Application No: WA/36/20/HH
Site Address: Murroes Dairy Lane Walberton BN18 0PT
Description of works: Demolition of porch and erection of new, single storey side addition, single storey side/rear addition.

Thank you for your internet representation made on 29th June 2020 which has been recorded as no objection with the comments as follows:

west elevation
proposed elevations

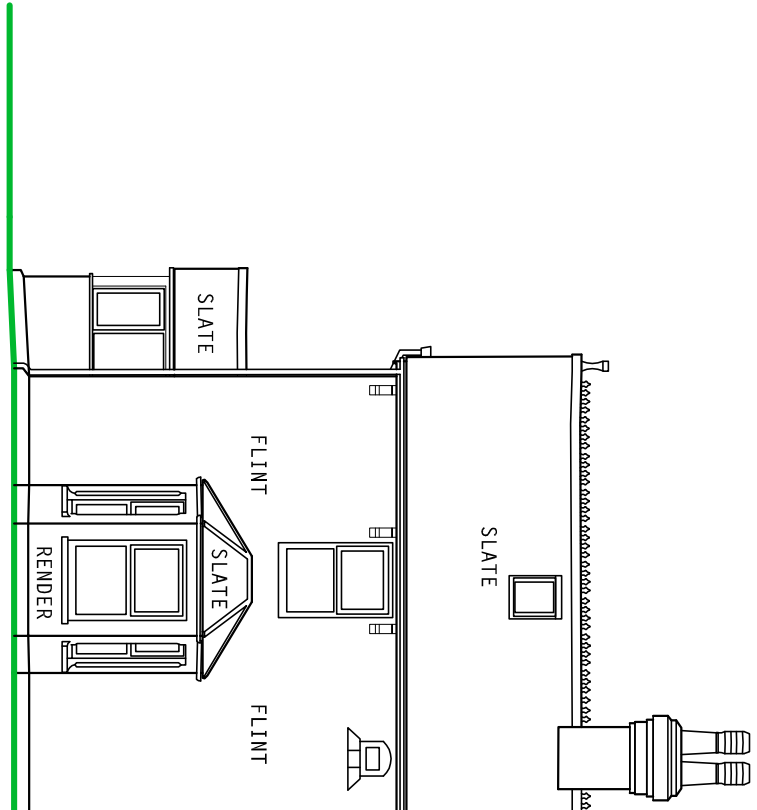
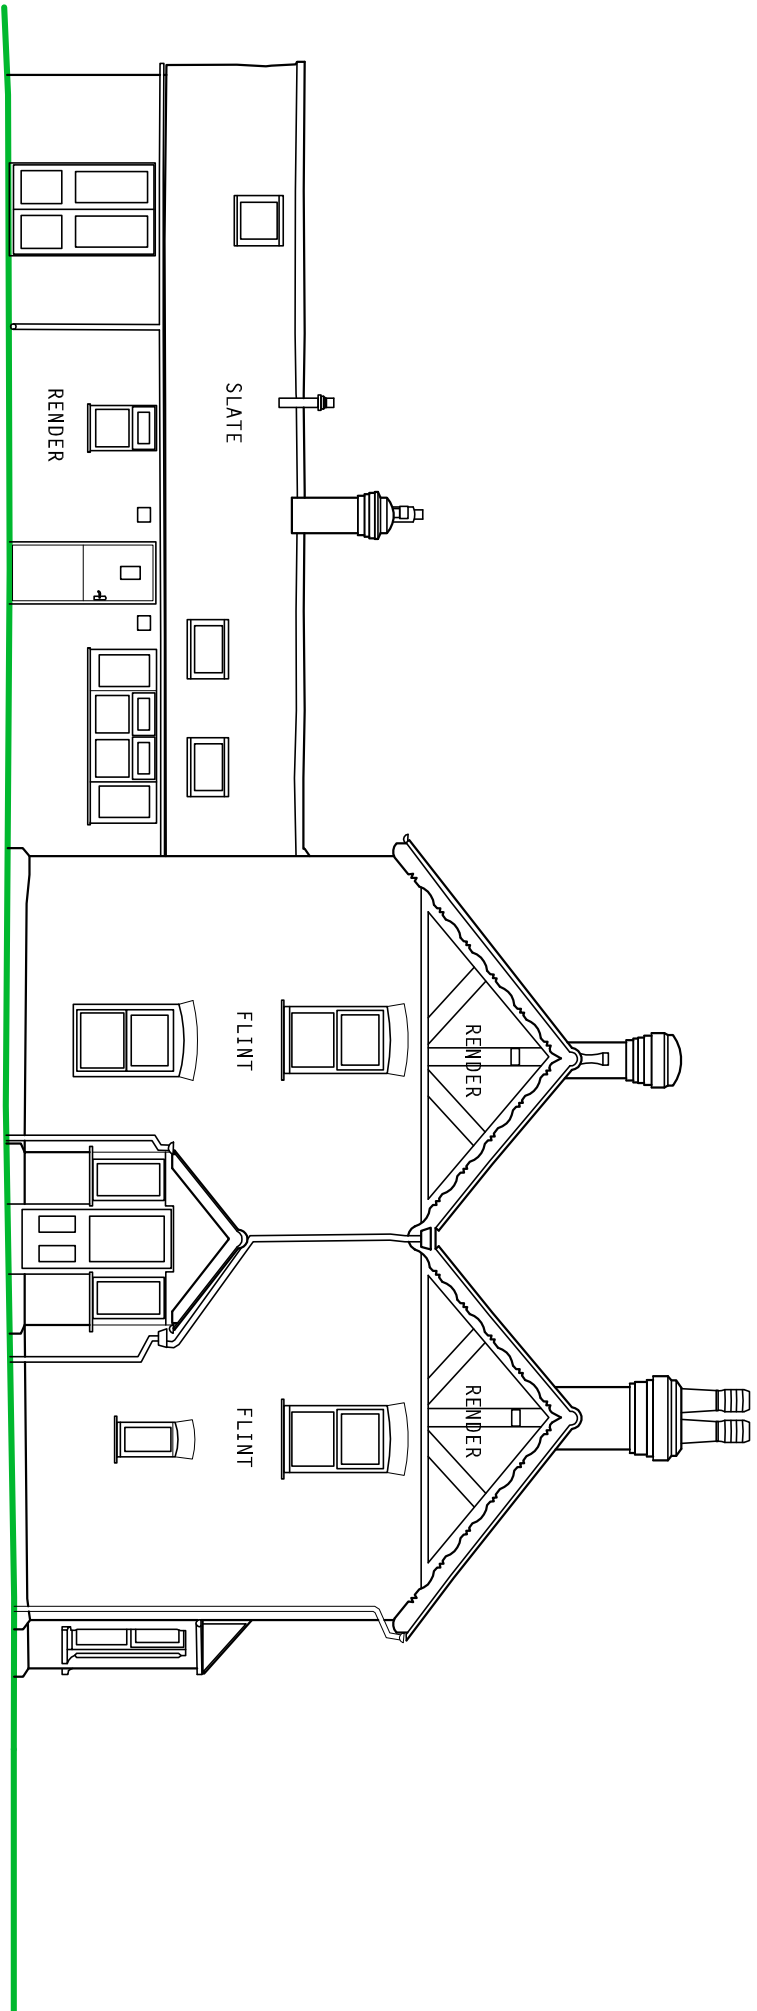
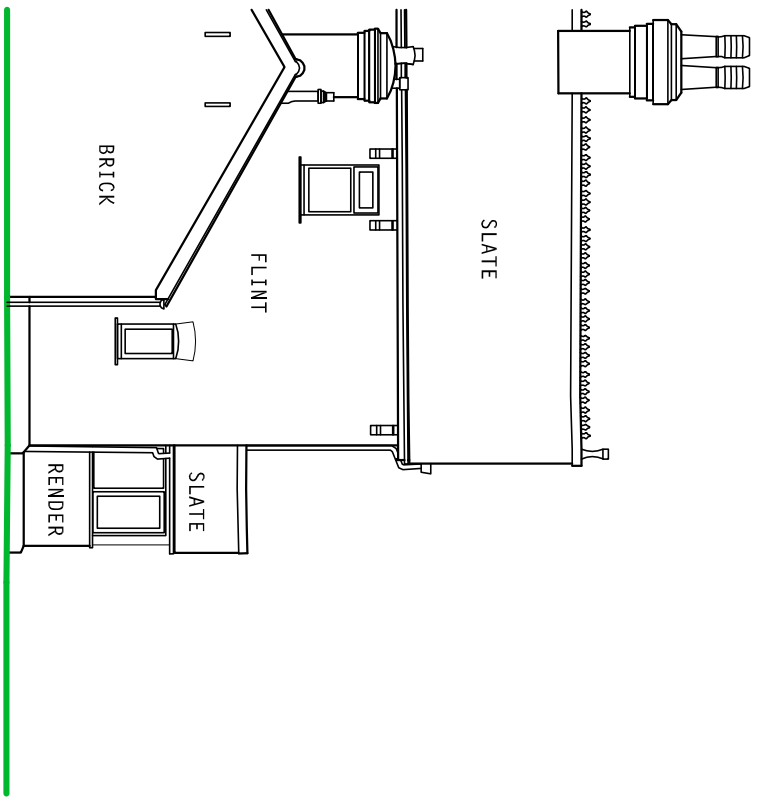
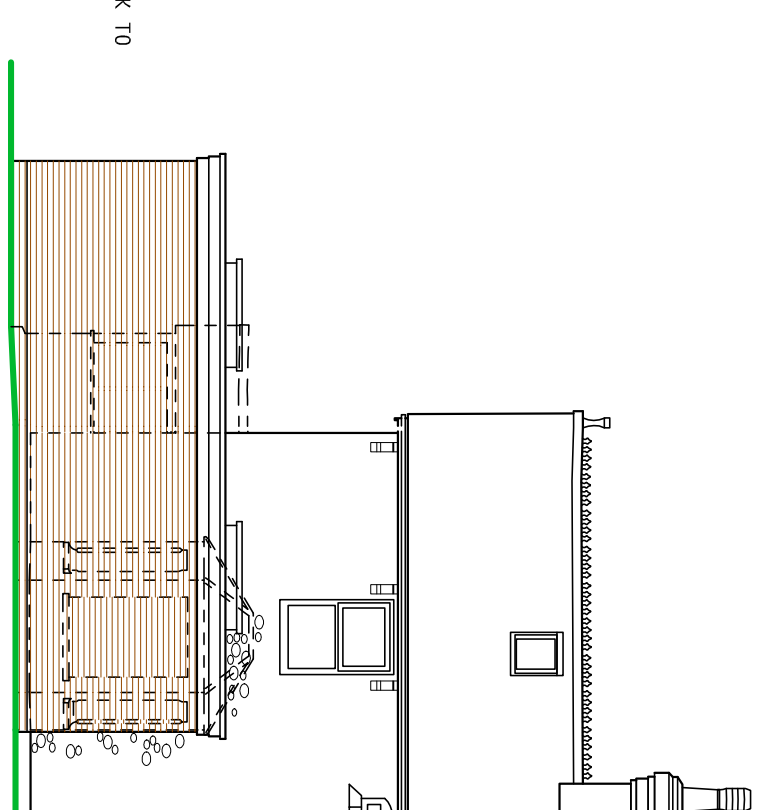
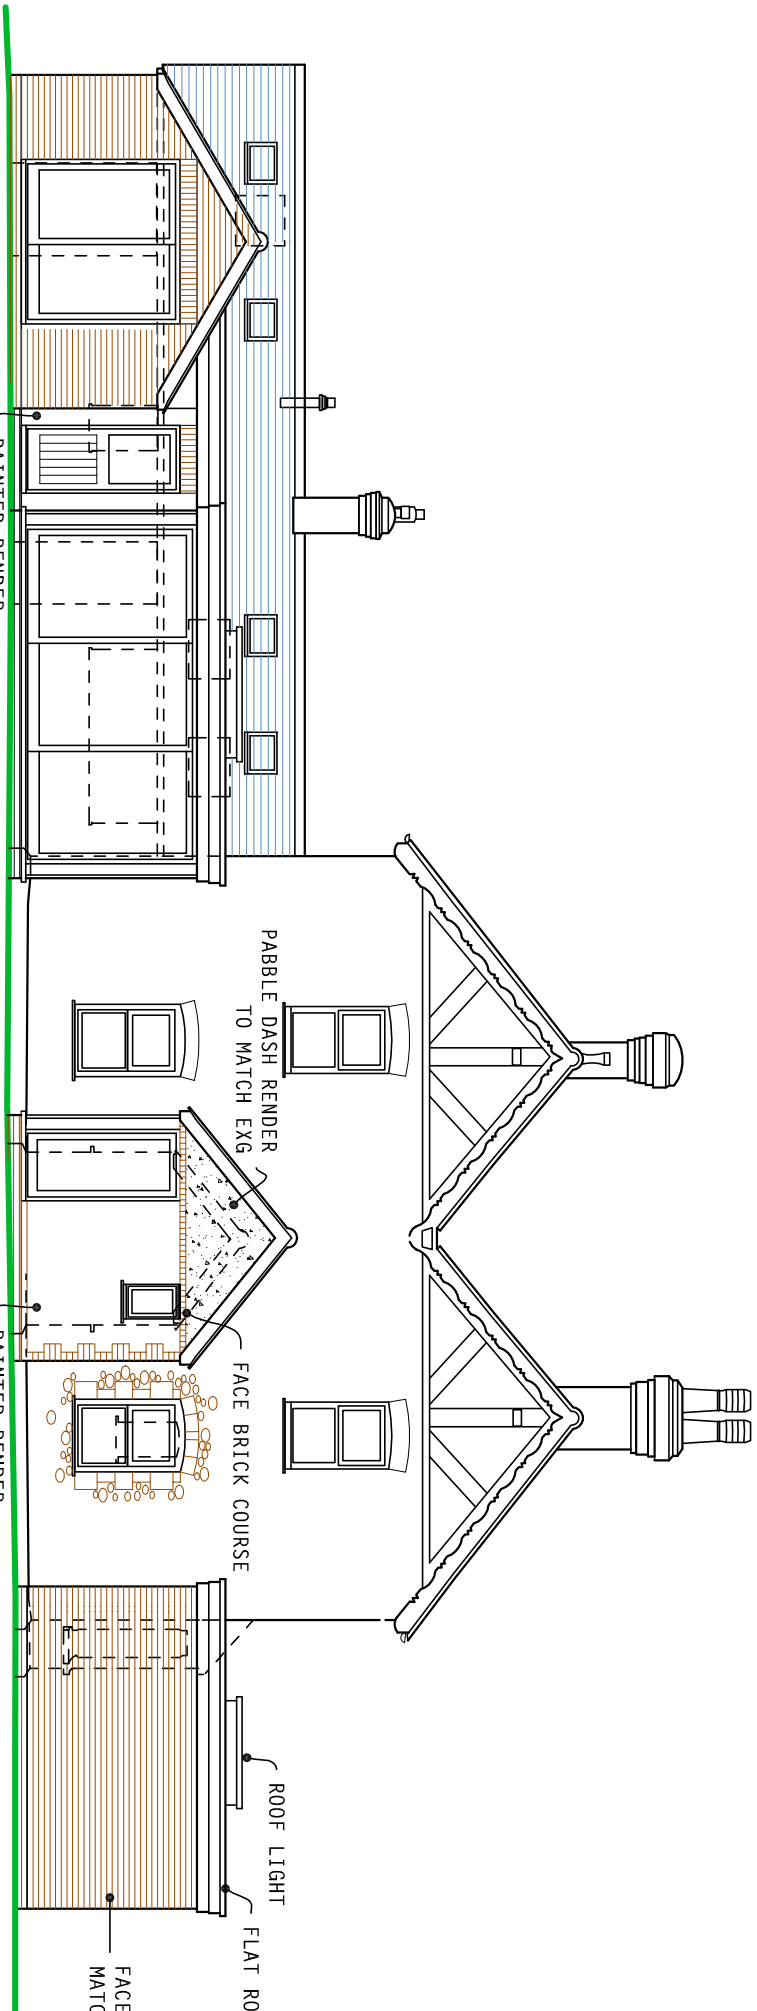
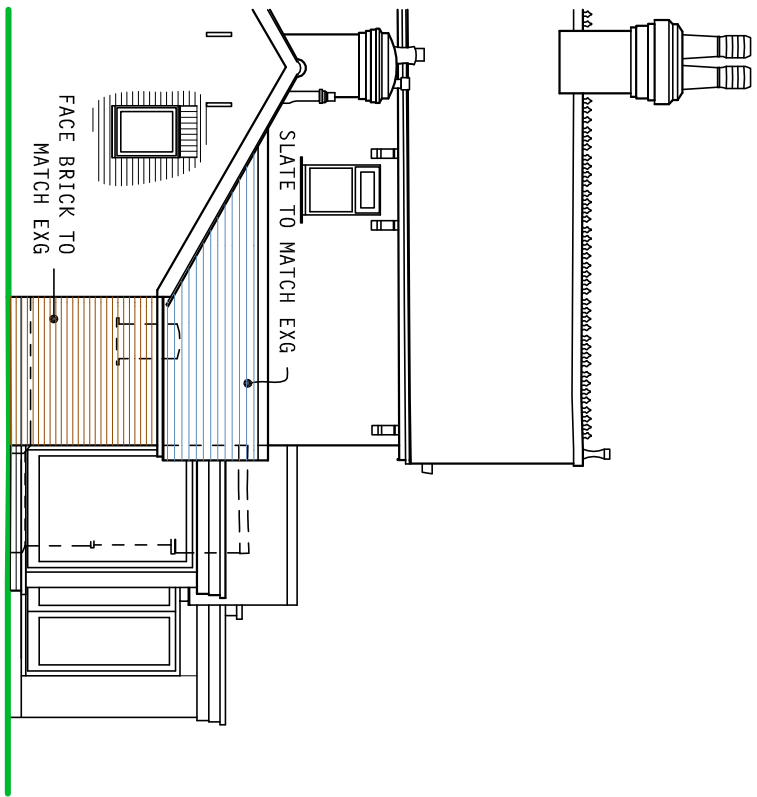
Walberton Parish Council has no objection to this application providing that the flint for the extension is to match the existing.
